# CITY OF ALBUQUERQUE

**Planning Department  
Transportation Development Services Section**

Re: **Certification Submittal for Certificate of Occupancy (C.O.)**  
Mountain America Credit Union, [D-20/D010A]  
8021 Ventura St. NE  
Architect's Stamp Dated 02/14/13

Based upon the information provided in your submittal received 02-12-13, the submittal is **not sufficient for acceptance** by Transportation Development Section for a Permanent Certificate of Occupancy. The following items need to be addressed :

SHEET TITLE: **GRADING PLAN**
SHEET NUMBER: **C-201**
PROJECT: 2013.0048 ORIGINAL ISSUE: 05/19/2012
D20/DC10A 1-13

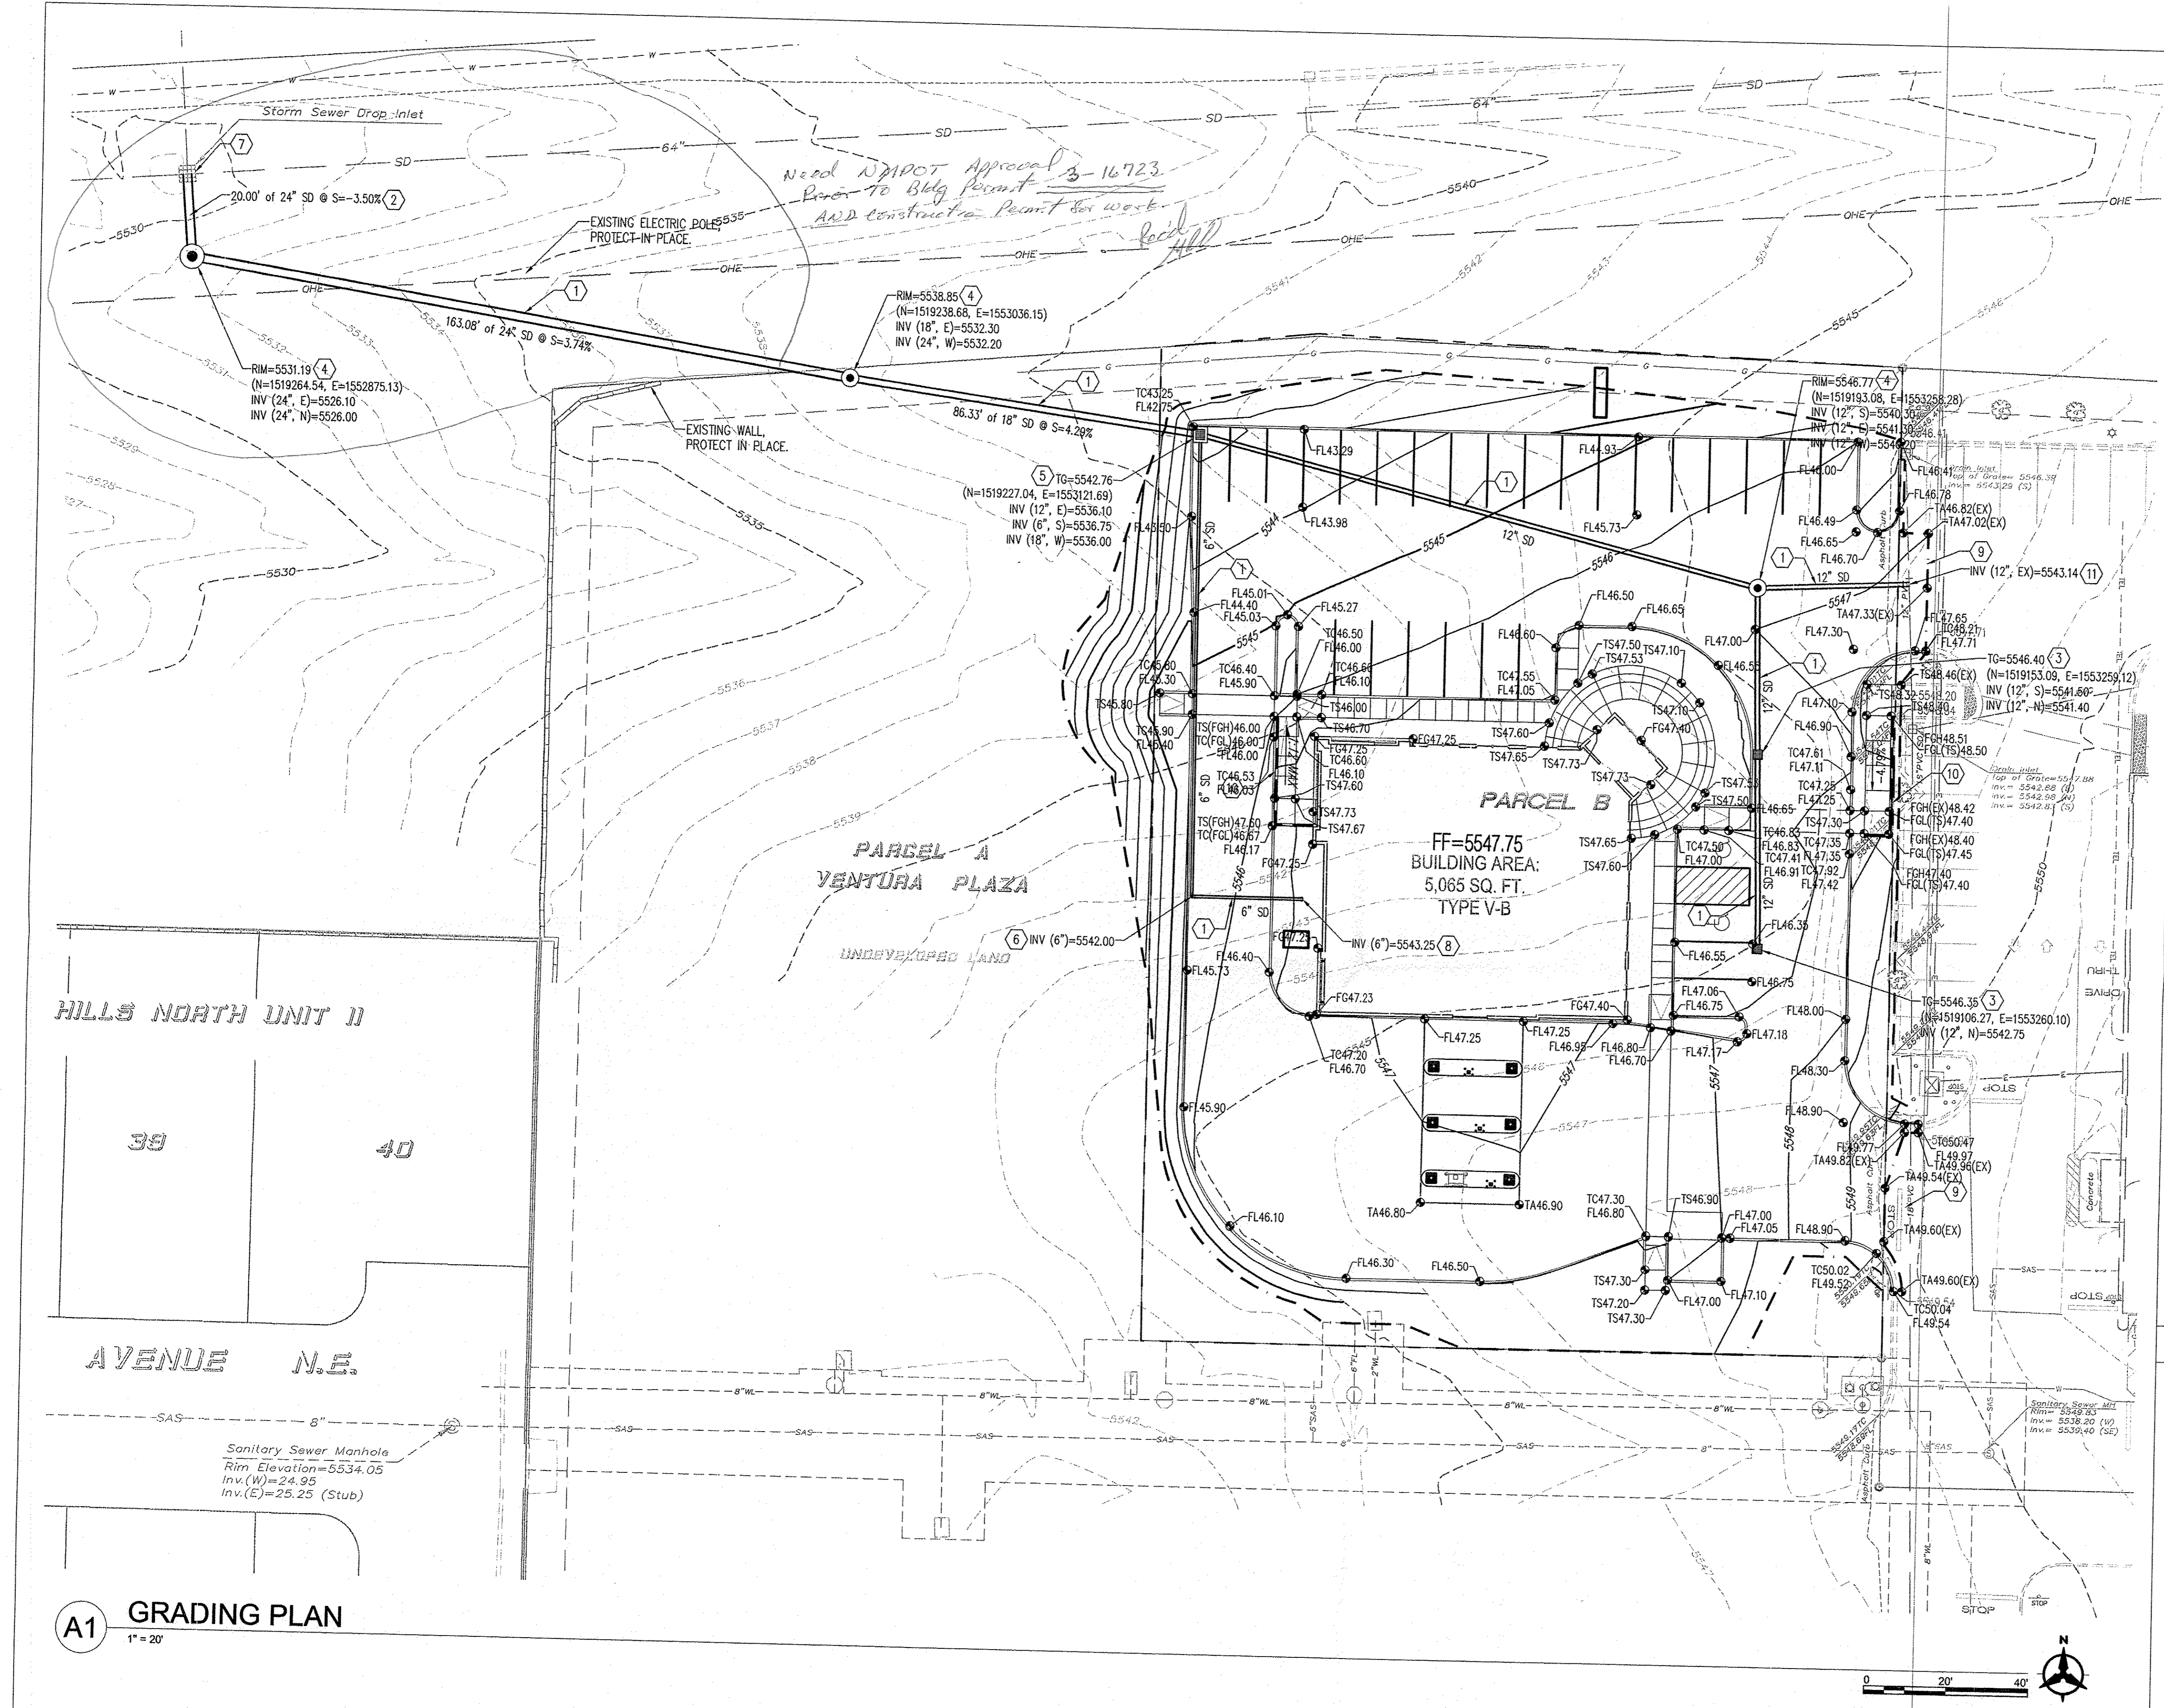
- ✓ 2. Since the 24" storm drain outfall at the NW corner of the site will tie into the 64" storm drain within the Paseo del Norte R/W, it will require approval and a permit from the NM-DOT, District 3. (Contact Timothy Trujillo, Drainage Engineer: 505-798-6690)

- ✓ 3. Prior to City approval of this plan, we require documentation (or email) from NM-DOT of their concurrence with work proposed within their R/W, and citing the PE Signature date on the plan that they approve.

4. This plan lacks a few presentation features required for Grading and Drainage Plans, per the DPM Chapter 22. Please review and update any revised submittal. If DOT approves this plan, I ask that you at least add a location map to the as-built Certification Plan.

1. This plan lacks a few presentation features required for Grading and Drainage Plans, per the DPM Chapter 22. Please review the criteria, and update future submittals. For this site, I ask that you at least add a location map to the as-built Certification Plan.
2. We will require documentation from NM-DOT of their acceptance of the storm drain connection at the NW corner of the site, authorized under NM-DOT Permit # 3-16723.

SHEET TITLE: SITE PAVING, STRIPING, & SIGNAGE PLAN
SHEET NUMBER: C-100
SCALE: 1" = 20'
PROJECT: 2013.0048 ORIGINAL ISSUE: 05/10/12

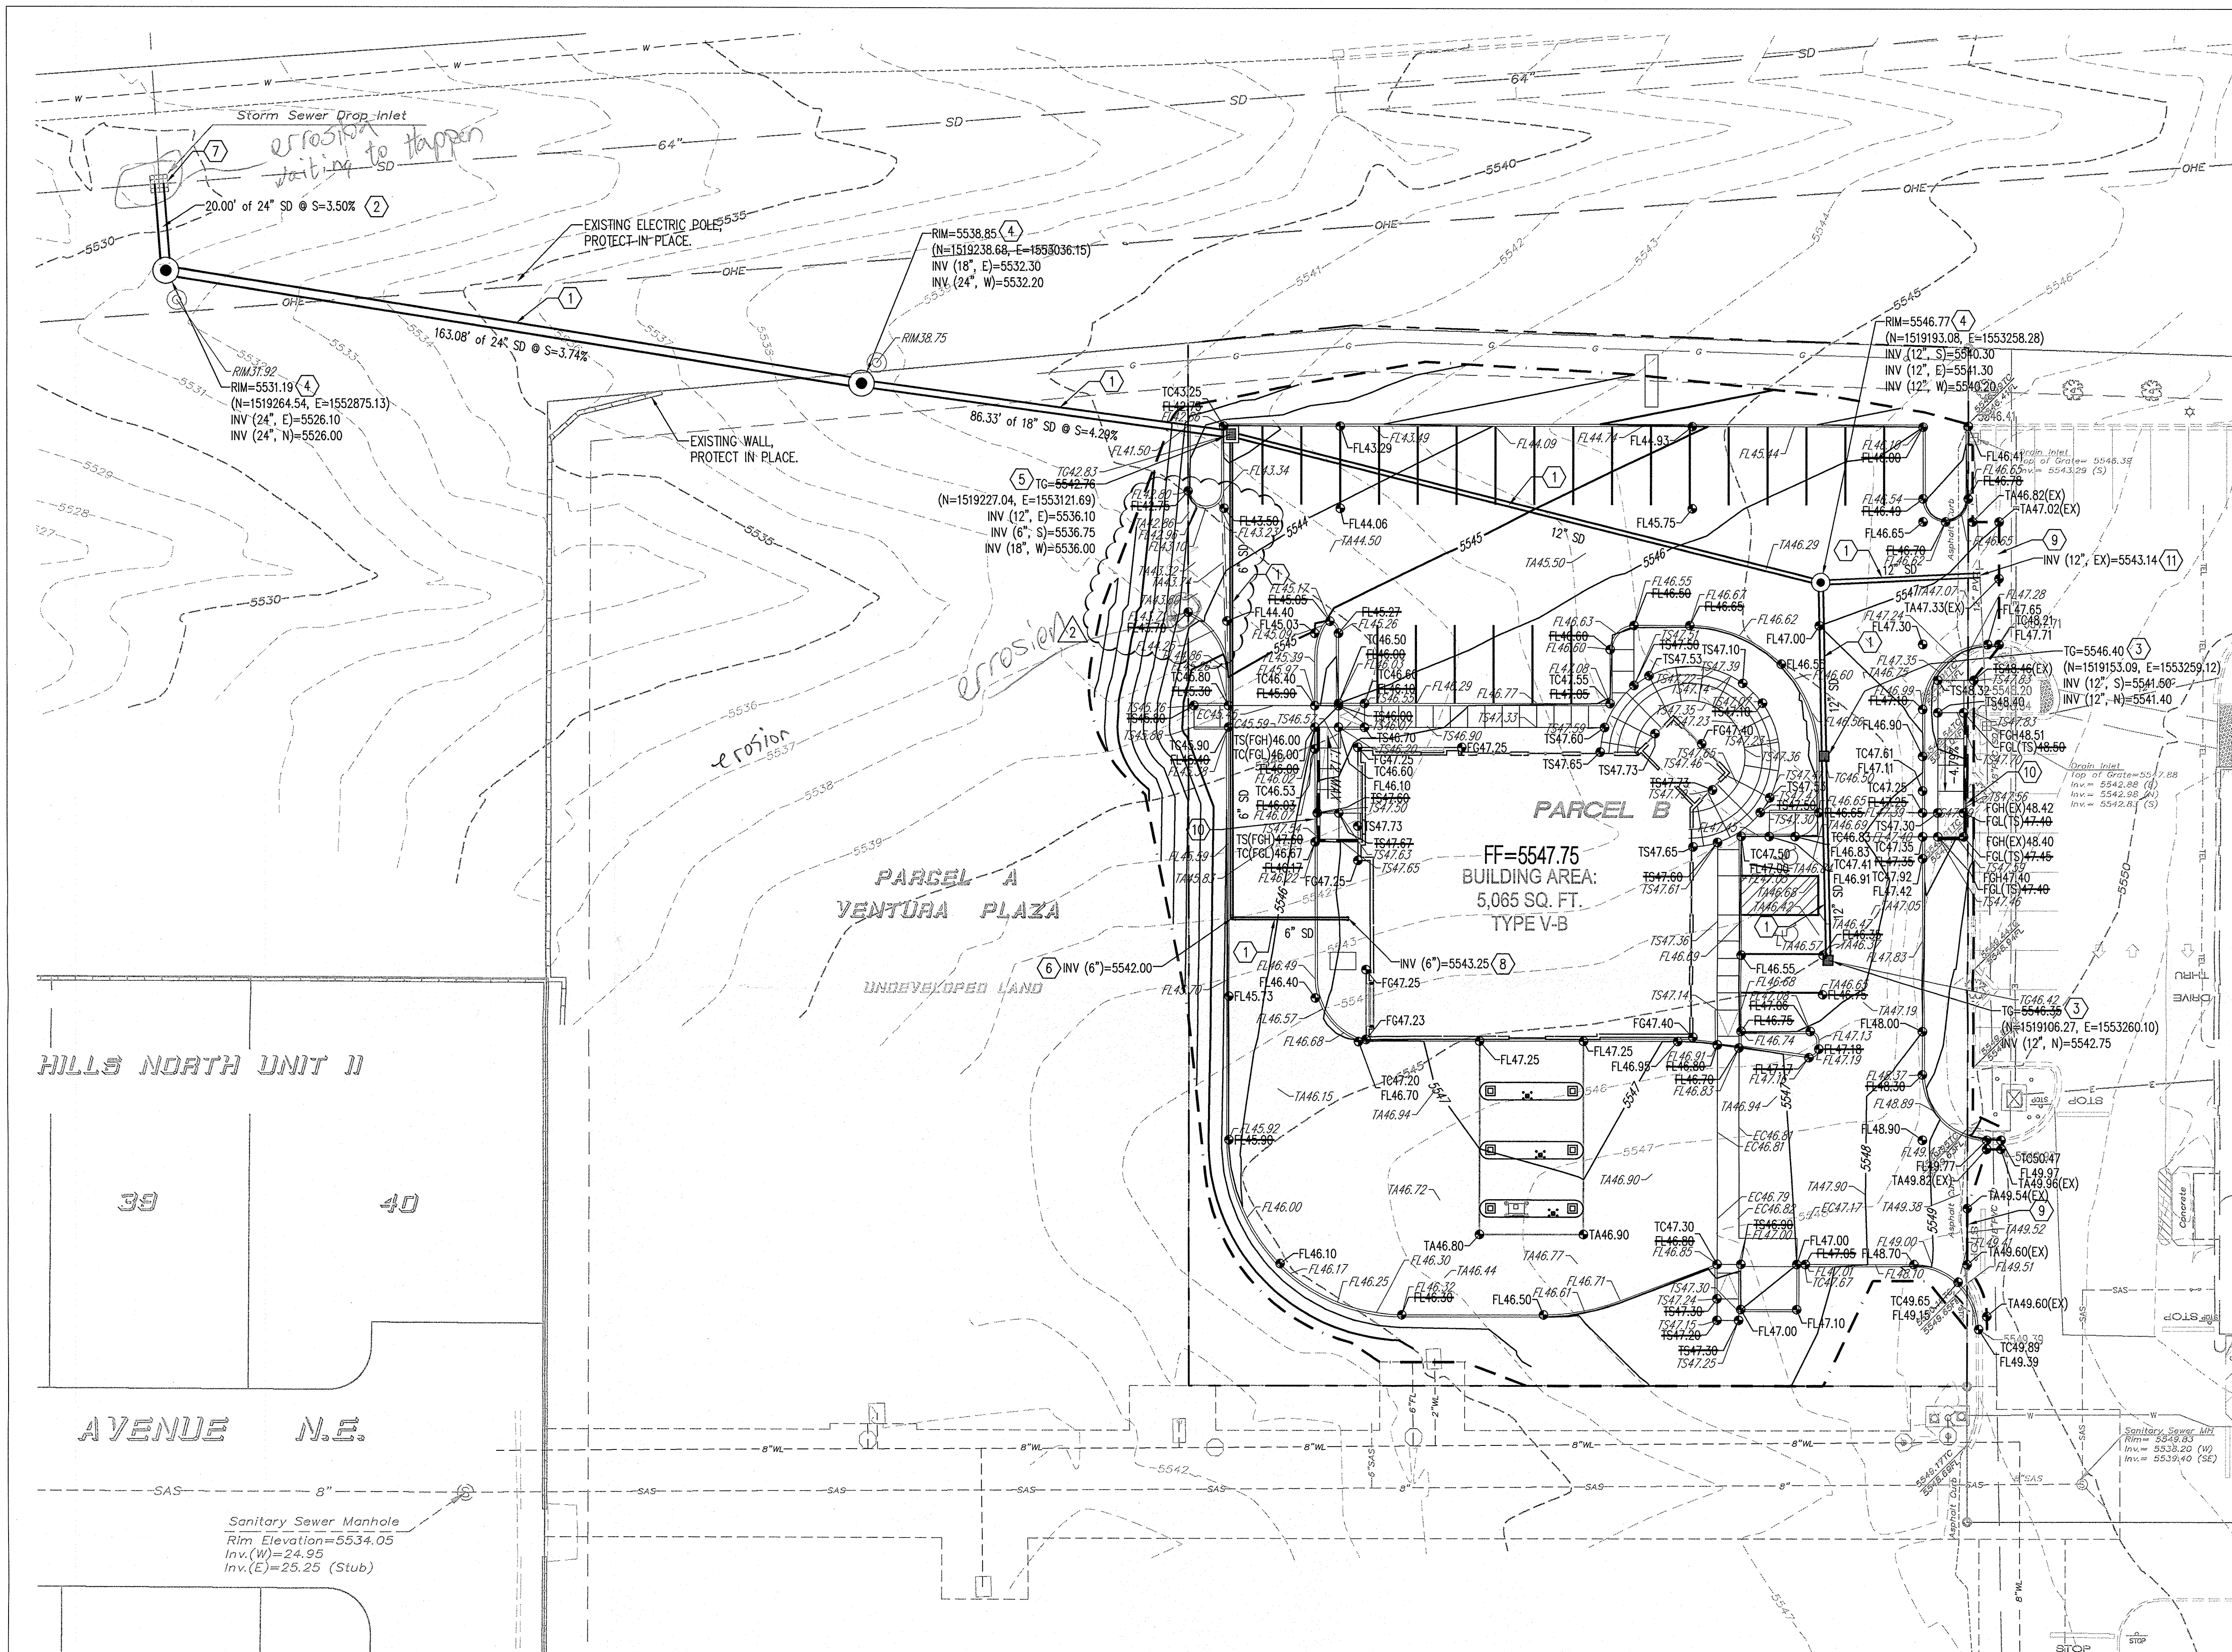
- Reference AA Site Plan as part of the certification (see attachment).
- Need to provide the original letter of Certification as part of the submittal.
